Applicant: Mr Payne

Proposal: Discharge of conditions 3 (schedule of materials), 4 (Secured by Design principles), 7 (biodiversity method statement), 9 (vehicular electric charging points) of 21/04156/F

Expiry Date: 30 September 2022

PROPOSED DECKING TO UPPER TERRACE

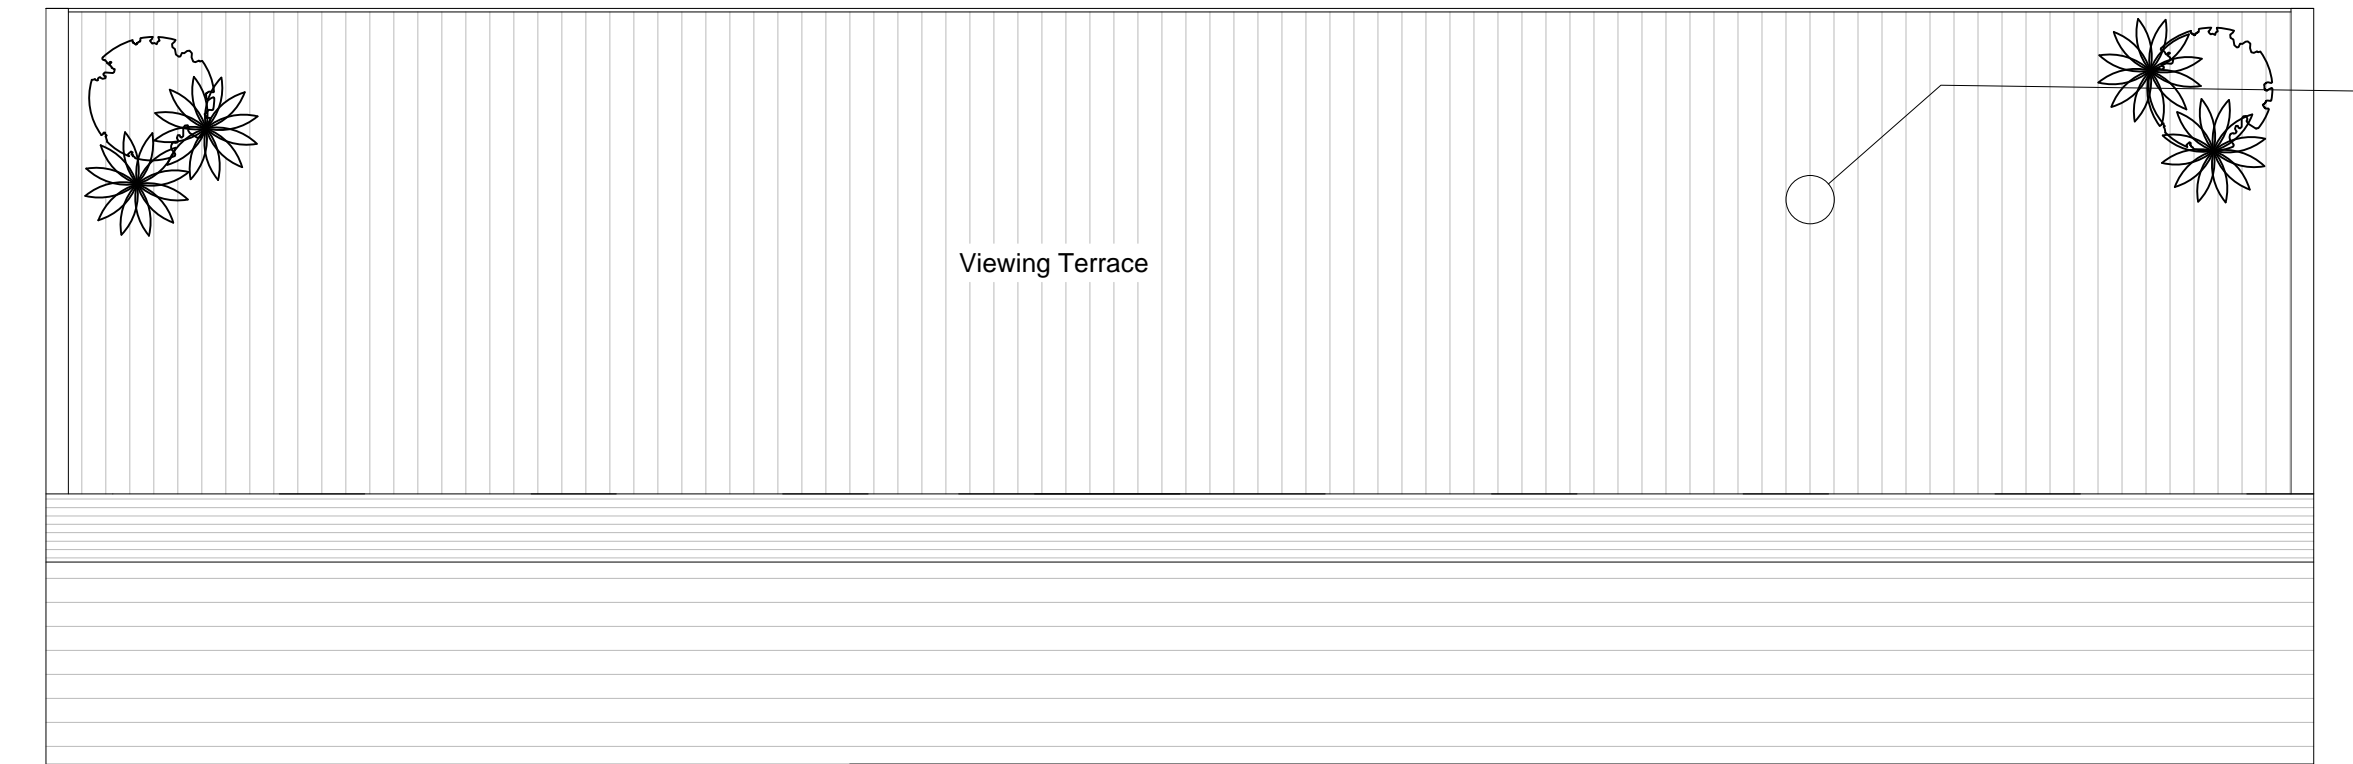
- 2.1. Condition 3 – required a schedule of materials and finishes. This was submitted in the form of Drawing No: PC1 indicating that the stone and mortar, including quoin detail, would match that of the existing hotel. The tiled roof would also match that of the existing hotel. Openings would be black powder coated aluminium, with glass balustrade supported by black metal posts. The decking to the upper terrace would be timber, with cast iron black rainwater goods.

- 6.1. Condition 3 – despite the schedule not including a sample panel of stonework, as requested, an image has been provided of existing stonework upon the existing hotel building that can be used for reference. I consider the choice of materials, matching those used within the wider site, is appropriate. The glass balustrade will avoid this appearing as an intrusive feature. I therefore recommend that this condition is discharged.
- 6.2. Condition 4 – The Agent has provided an explanation of the measures from the Secured by Design document that would be incorporated into the scheme and I consider this to meet the requirement of condition 4.

Materials and finishes in accordance with Drawing No: PC1 received with the original application on 11 July 2022.
